Application for a non-material amendment following a grant of planning permission.

Unit:		House number:		House suffix:	
House name:	BUILDING PLOT				
Address 1:	18 STONEGATE				
Address 2:	COWBIT.				
Address 3:	SPALDING.				
Town:					
County:	1900 7 117				
Postcode (optional):	PE12 6AH				
Description of location or a grid reference. (must be completed if postcode is not known):					
Easting:		Northings:			
Description:

THREE BEDROOM DETACHED BUNGALOW WITH DETACHED GARAGE

H 01-0290-10

Drawing Number 777/520 SHEET 1/A

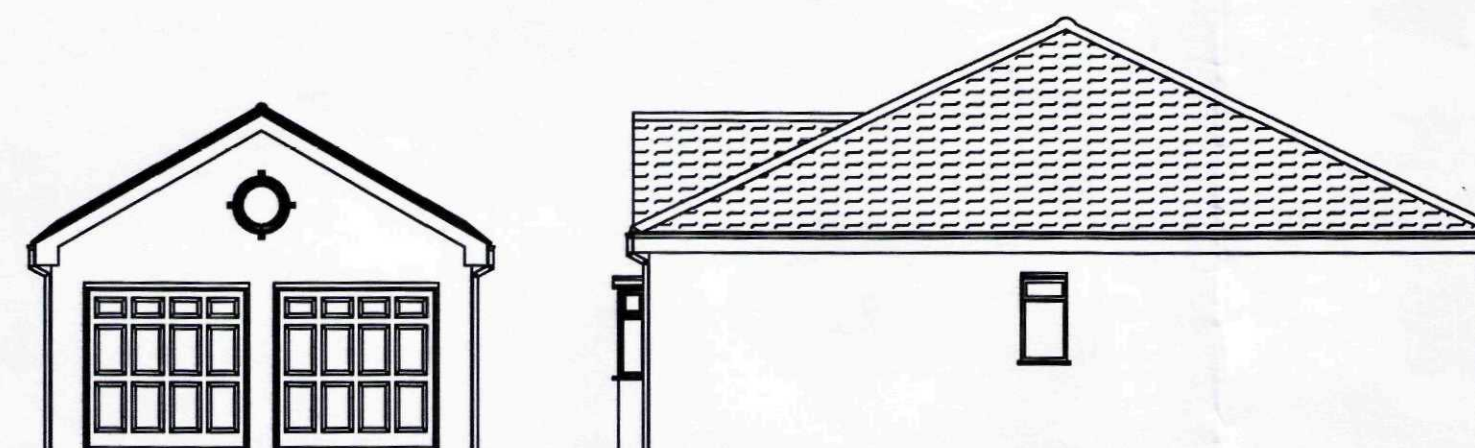
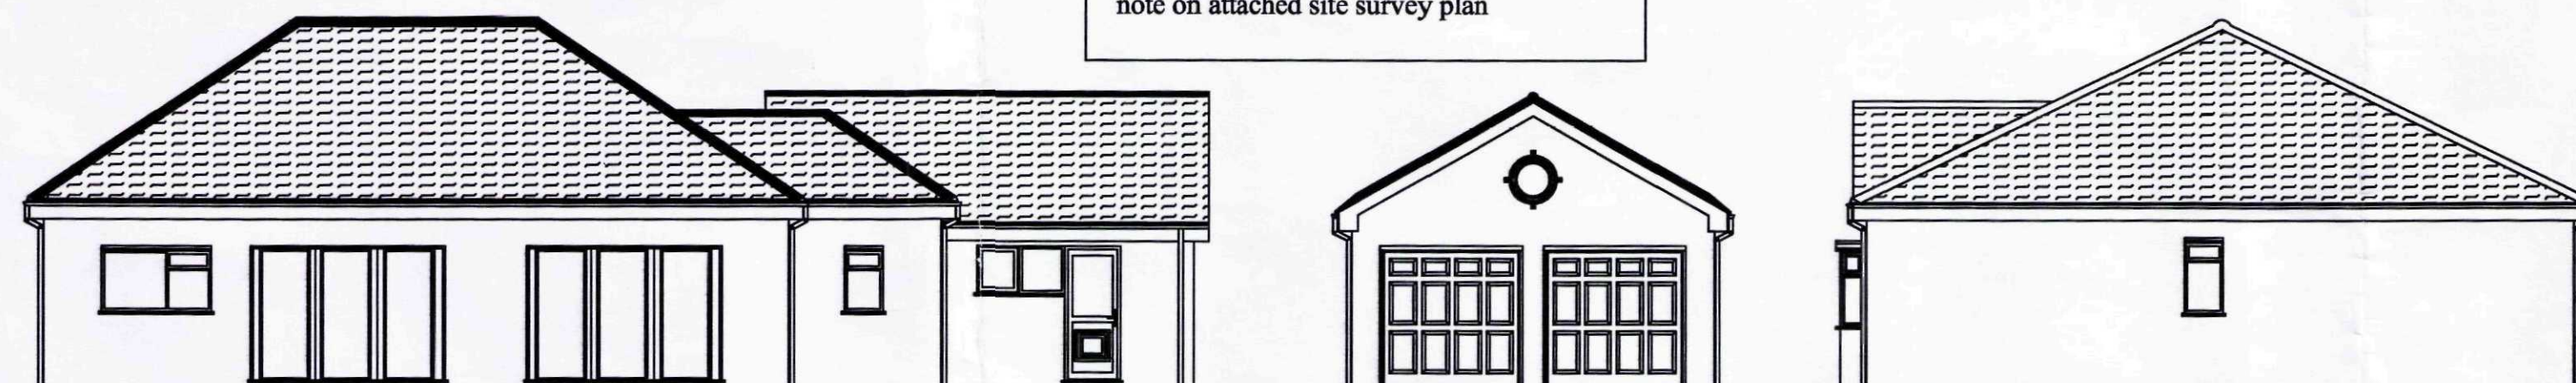
WINDOW TO REAR CLOAKROOM ELEVATION
WINDOW TO KITCHEN REAR ELEVATION
CHANGE LOUNGE FRENCH DOOR TO BI-FOLD DOOR TO
REAR ELEVATION.

TO ACTIVE NATURAL LIGHT INTO CLOAKROOM AND KITCHEN
TO ENTRANCE ACCESS AND APPEARANCE TO MATCH KITCHEN
BI-FOLD DOORS.

777/520-SHEET 1A.
